**Subject: Comments for Design Review Board on
December 04, 2019
Albuquerque, Bernalillo County, District Three**

Project Number: PR-2018-001470

Case Description: Site Plan

Location: 12th Street and Menaul Blvd Southwest Quadrant

**SHEET TITLE**  
**SITE PLAN FOR BUILDING PERMIT**  
**AS-101**

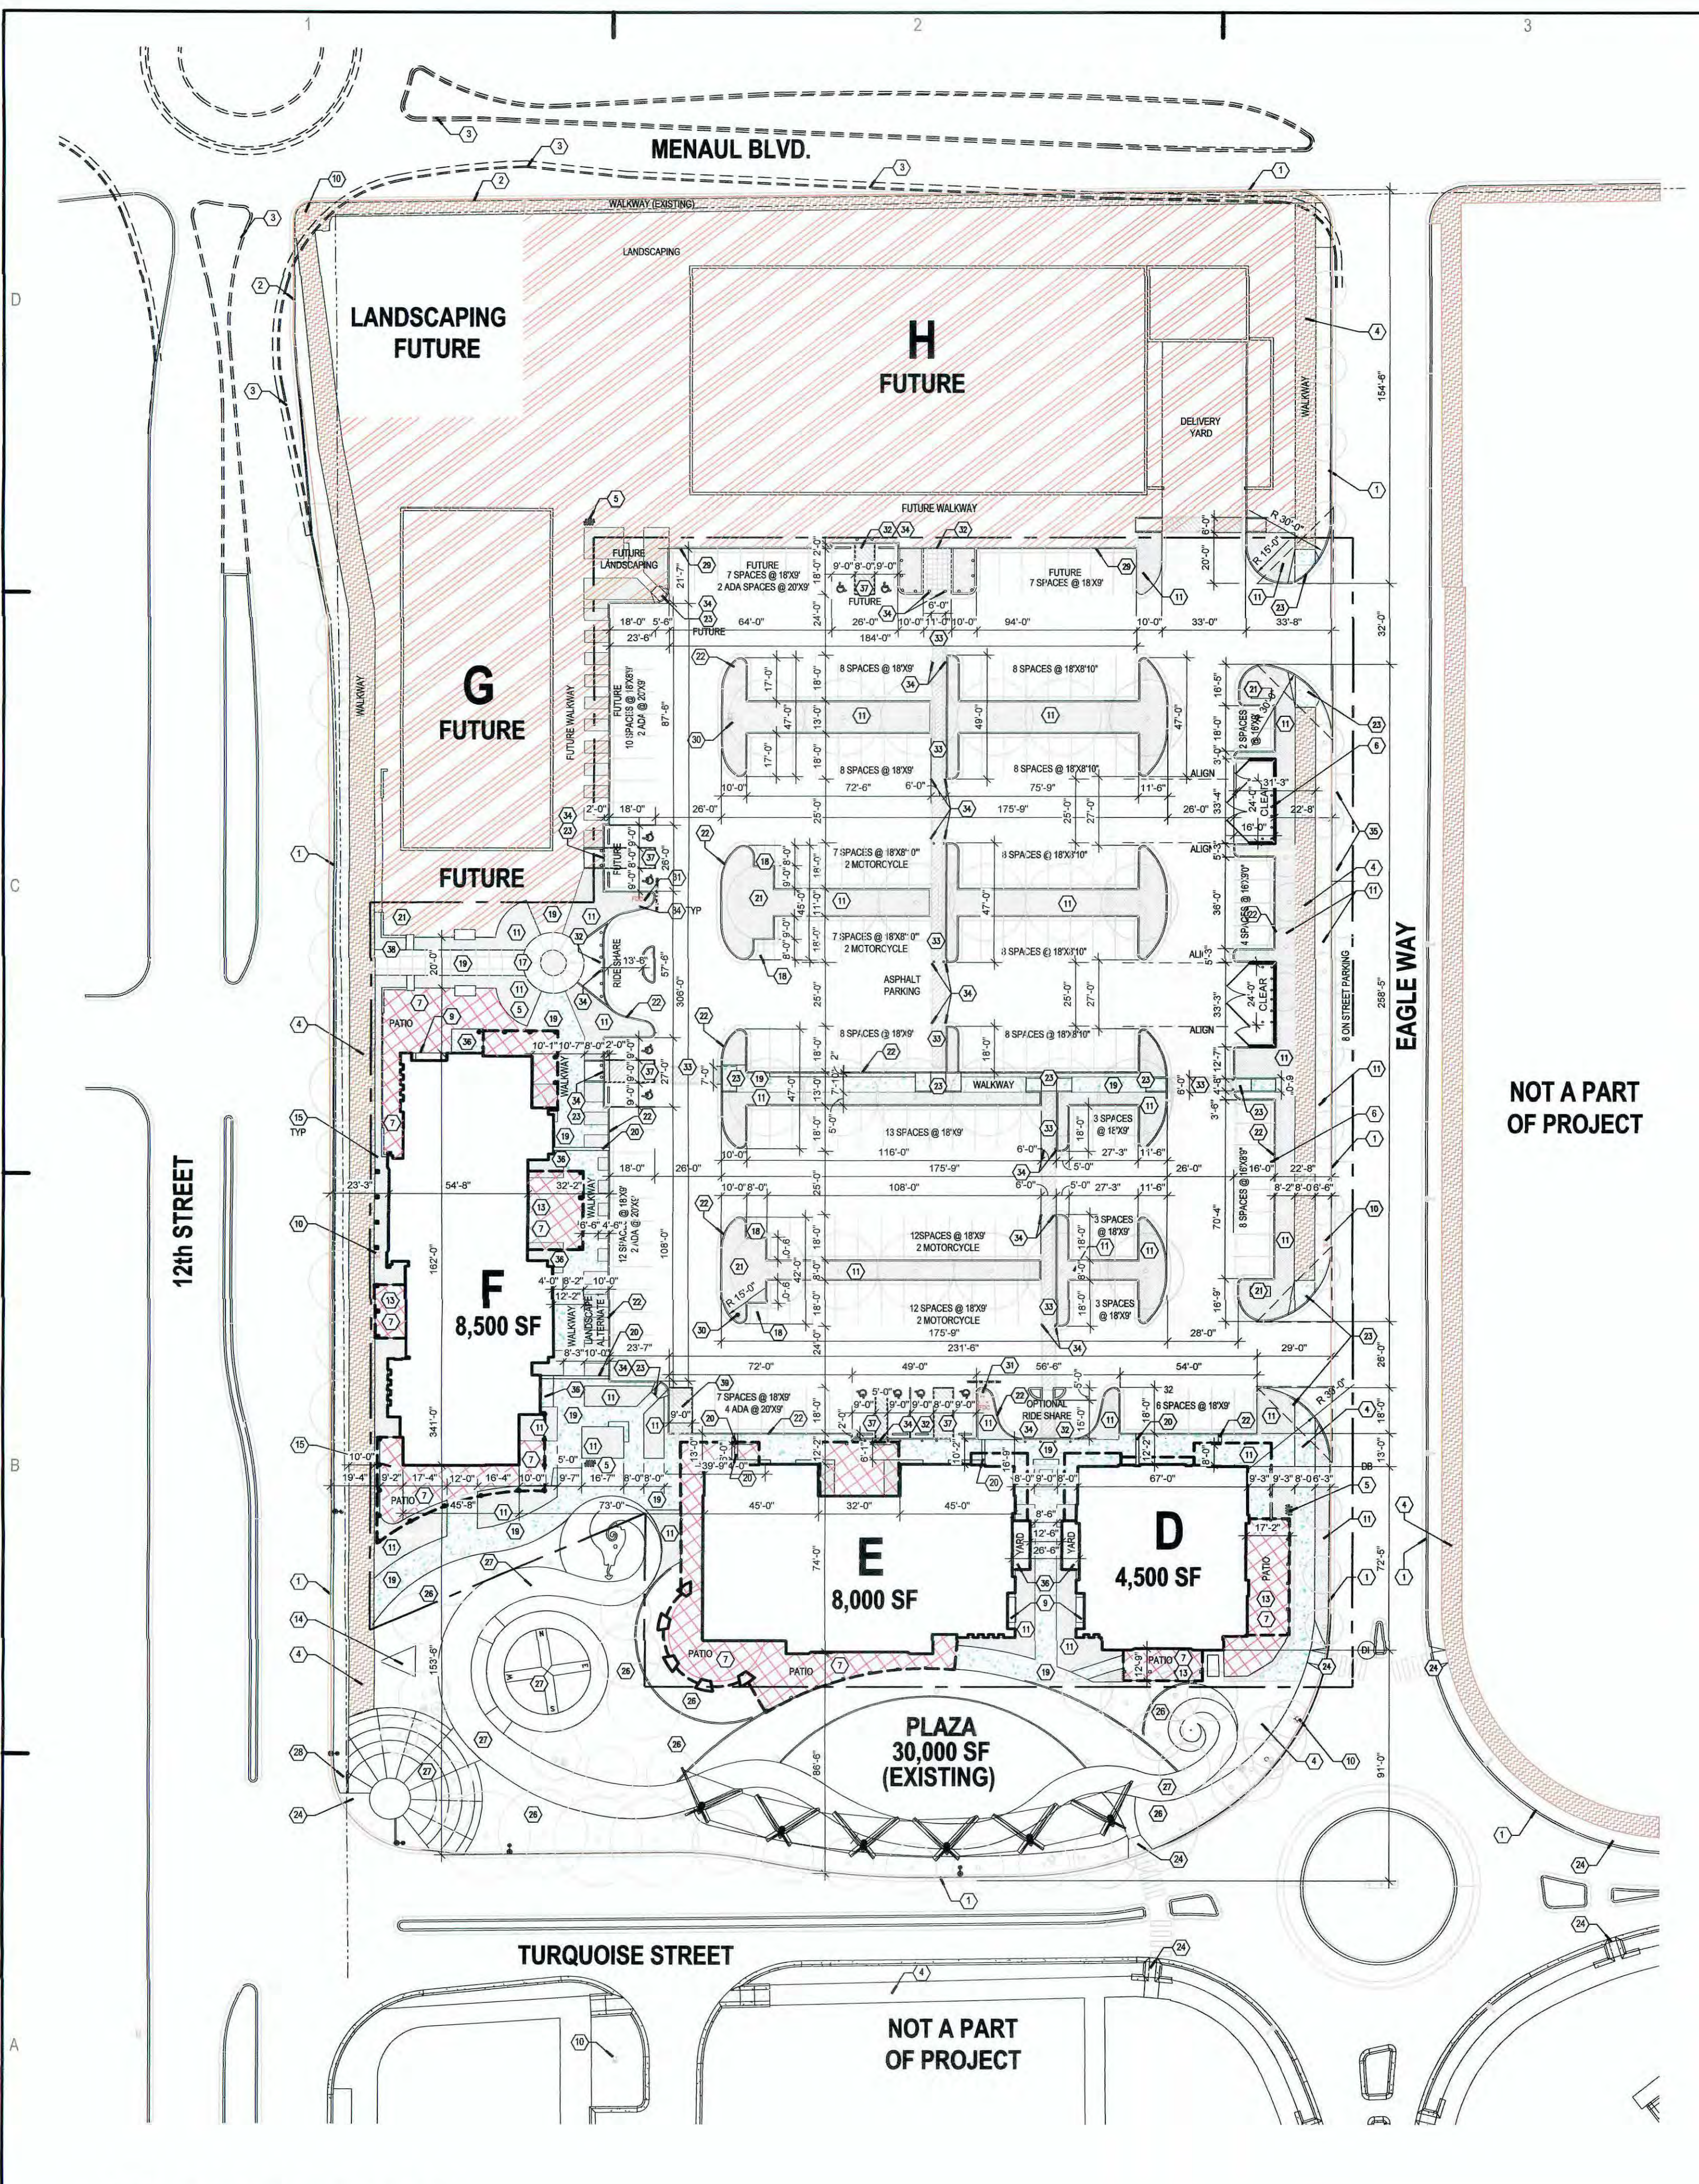
- The NMDOT is requiring the owner / engineering consultant contact Margaret Haynes (505) 288-2086 margaret.haynes@state.nm.us as to discuss this development's TIA and potential impacts on I-40 and 12th street as it falls within 2640 feet of the interstate.
